RE: Hundley Administrative Segregation (Boundary Line Adjustment), SG-08-00032

TO: Jeff Watson, Community Development Services  
FROM: Christina Wollman, Planner II *CW*  
DATE: February 17, 2011  
SUBJECT: Hundley SG-08-00032

Subject: 12 Parcel Segregation and BLA<sup>08</sup>  
Segregation (SG-~~10~~-00032) Hundley  
I 90, Exit 78 vicinity - Northerly side of Interchange.

PROPOSED

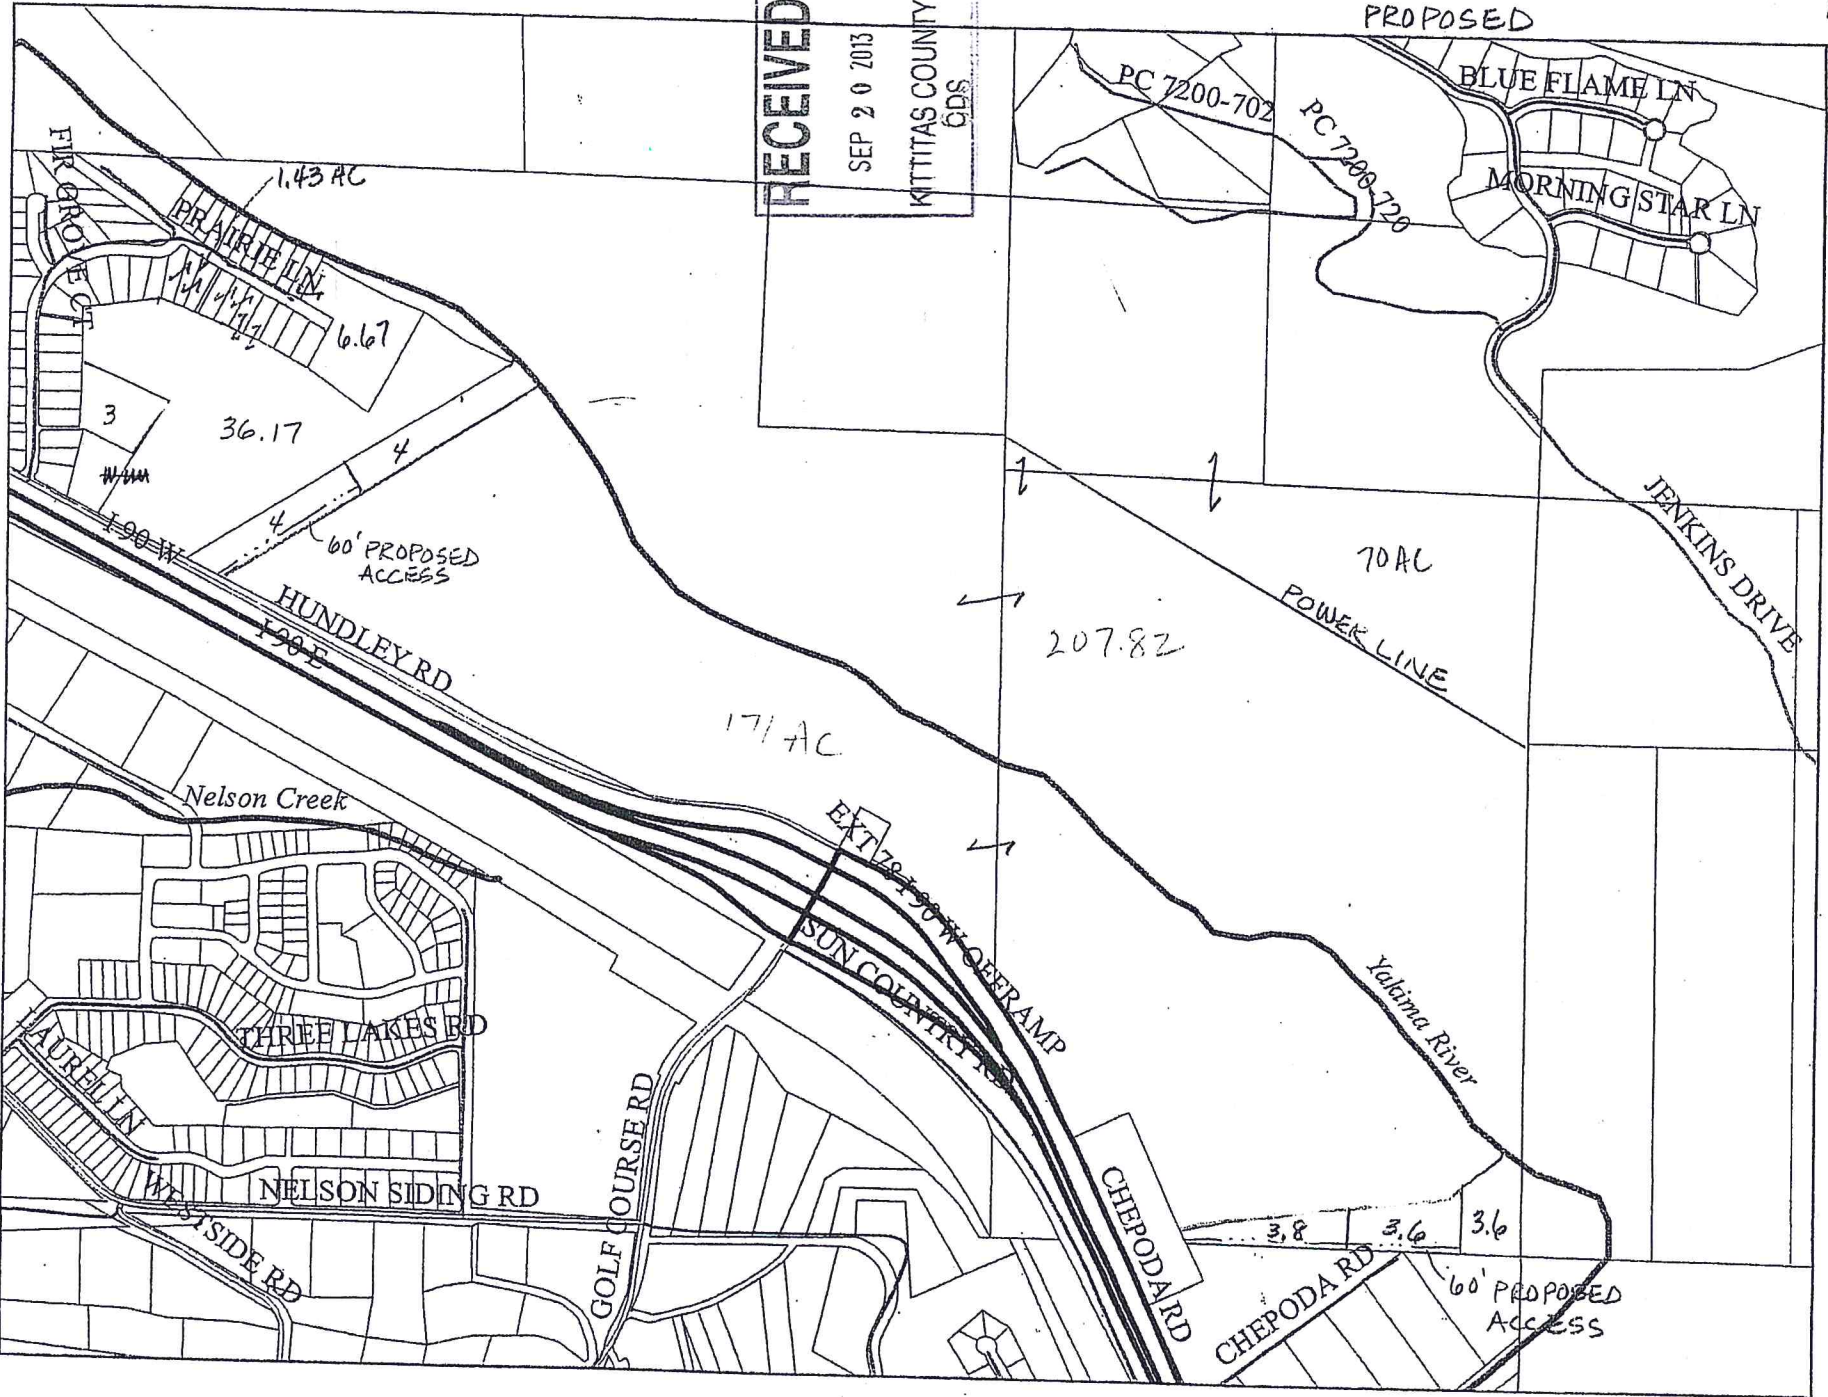
- a. Chepoda Road is a WSDOT owned frontage road. The boundary line adjustment proposes access to the 3.8, 3.6 and 3.6 acre parcels from the end of Chepoda Road. WSDOT requires that as a condition of approval, the entire road must be constructed to Kittitas County Public Road Standards.

- b. To avoid the requirement to improve Chepoda Road, all lots may be accessed from Hundley Road.
- c. Easements shall not extend to the 3.8-acre WSDOT owned parcel, and no access across the WSDOT owned parcel shall be allowed.

2. The 60' proposed access shown at the end of identified "Chepoda Road" must terminate at the 3.8 acre parcel, and not extend to the rectangular shaped parcel to the west that is owned by the WSDOT (see attachment). No access across this parcel owned by the WSDOT, or the haul road, will be allowed.
